SITE DEVELOPMENT PLANS FOR SUPER STAR CAR WASH FALCON MARKETPLACE LOT 10

PCD FILING NO.:
PPR-21-008

REVISION	DATE	DESCRIPTION	REVISION	DATE	DESCRIPTION
1	07/15/2021	SSCW - FALCON MARKETPLACE - 2ND SDP SUBMITTAL

SUPER STAR CAR WASH - FALCON MARKETPLACE LOT 10
SITE DEVELOPMENT PLAN

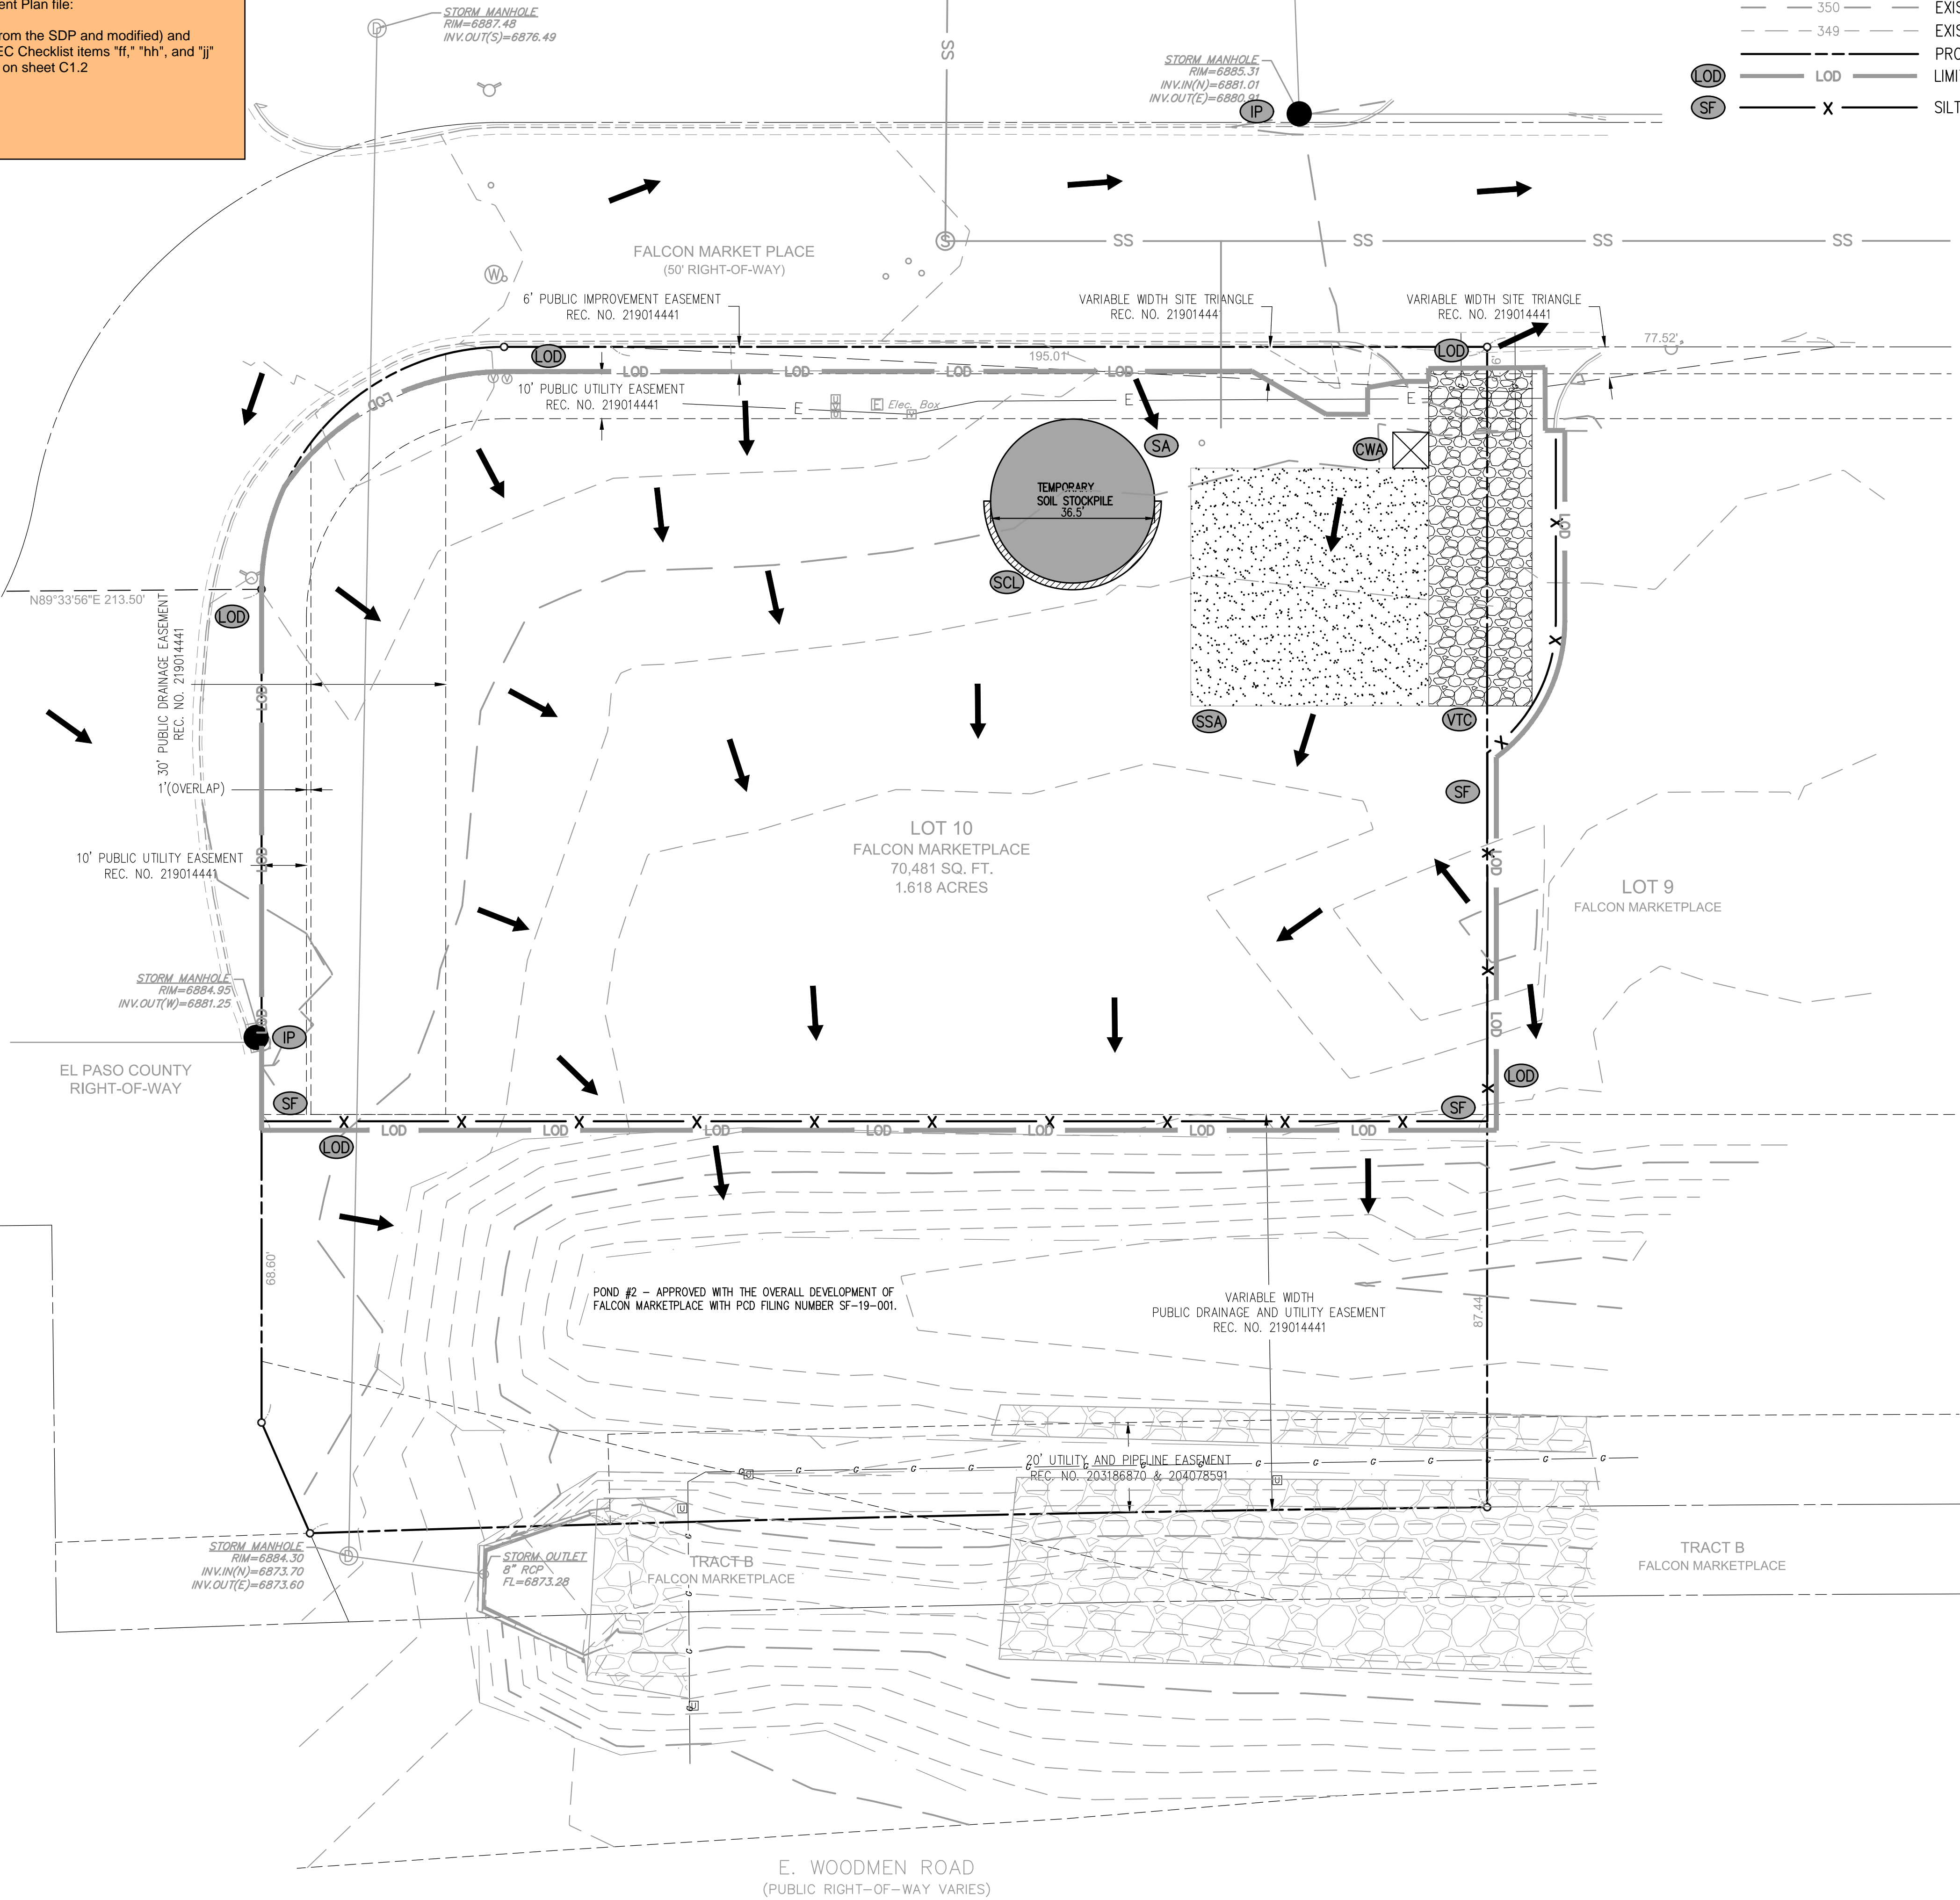
Please remove sheets C2.0 through C4.0 and incorporate as separate GEC plan and add a note page and cover sheet for the GEC plan.

and provide the signature blocks below and the County Engineer's signature block
